Phone: 0300 123 6780
Email: Kathryn.Walsh@lancashire.gov.uk
Your ref: 3/2024/0853
Our ref: 3/2024/0853/HDC/KW
Date: 05 February 2025

Location: Land off Longridge Road Hurst Green BB7 9QP
Proposal: Proposed agricultural building. Regularisation of works to existing access and access track.
Grid Ref: 367109 438189

Summary

BLOCK/SITE PLAN
AREA 90m x 90m
SCALE 1:500 on A4
CENTRE COORDINATES: 367082, 438111

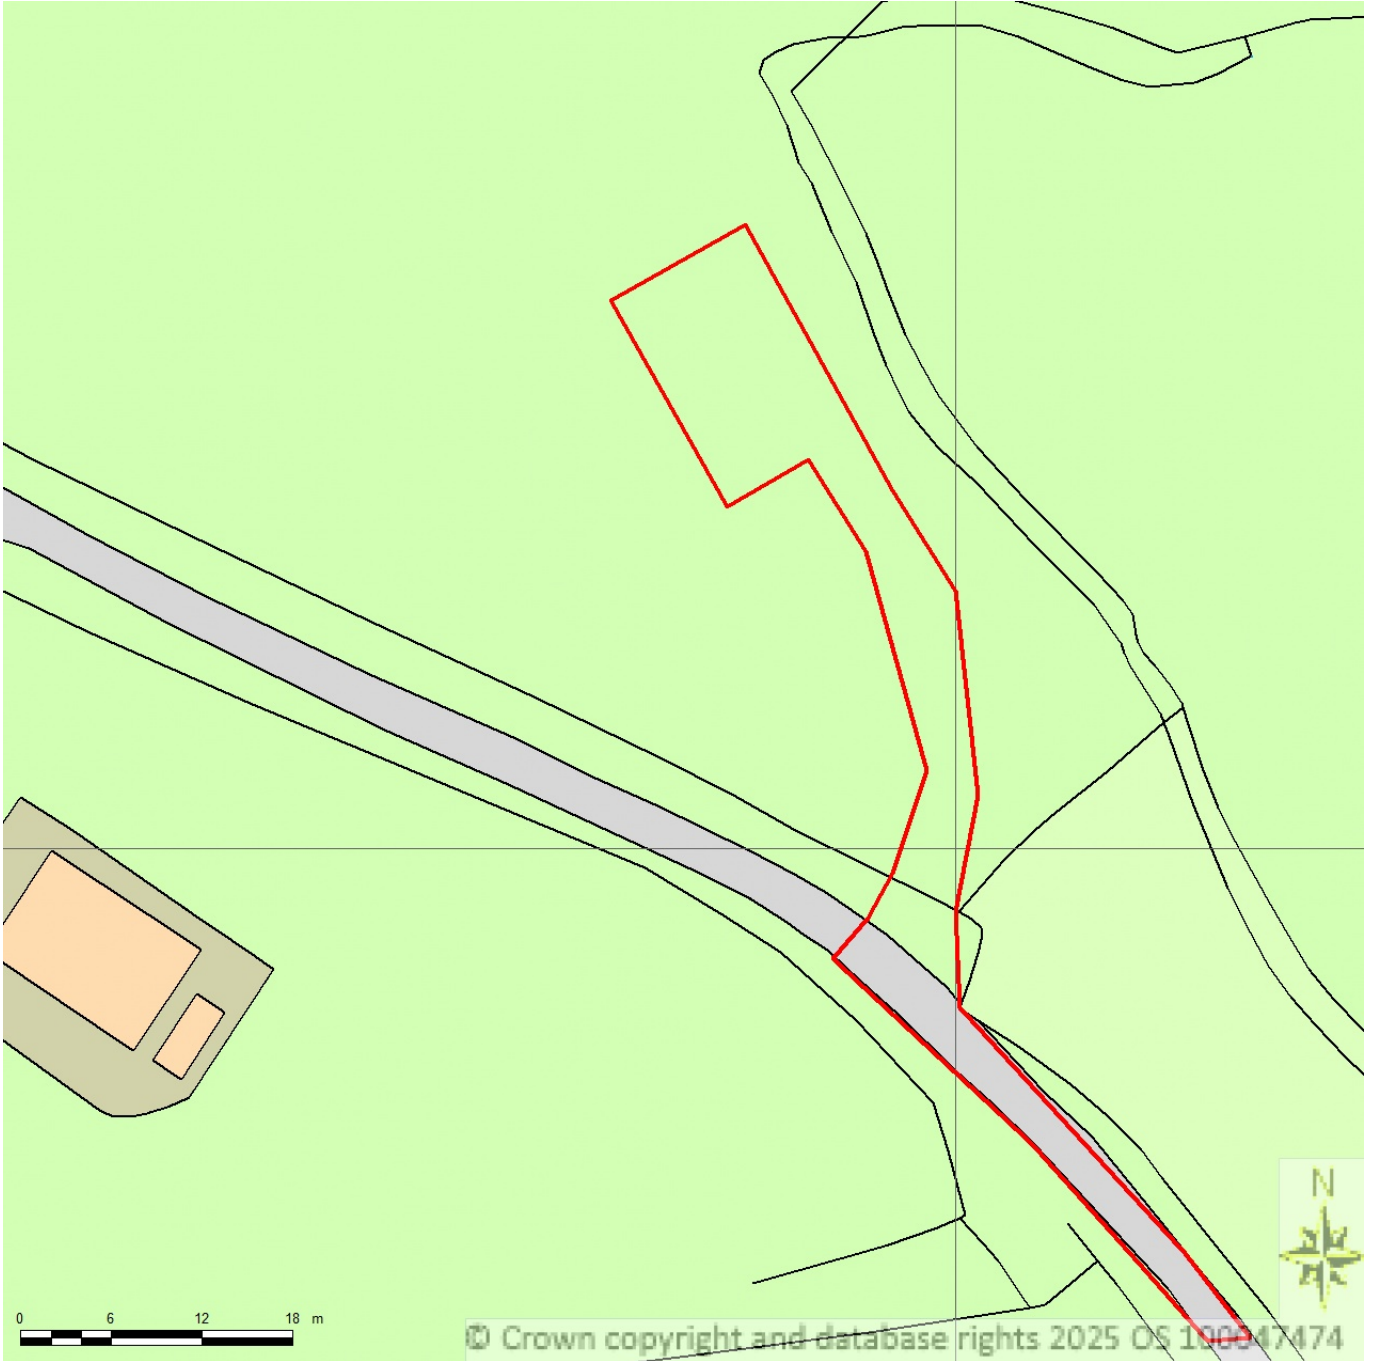
The LHA has reviewed the Proposed Block/Site Plan and are aware that an internal track has been created between the access and the area in which the agricultural building is proposed. There is room for a vehicle to park and turn within the site allowing ingress and egress in a forward gear.
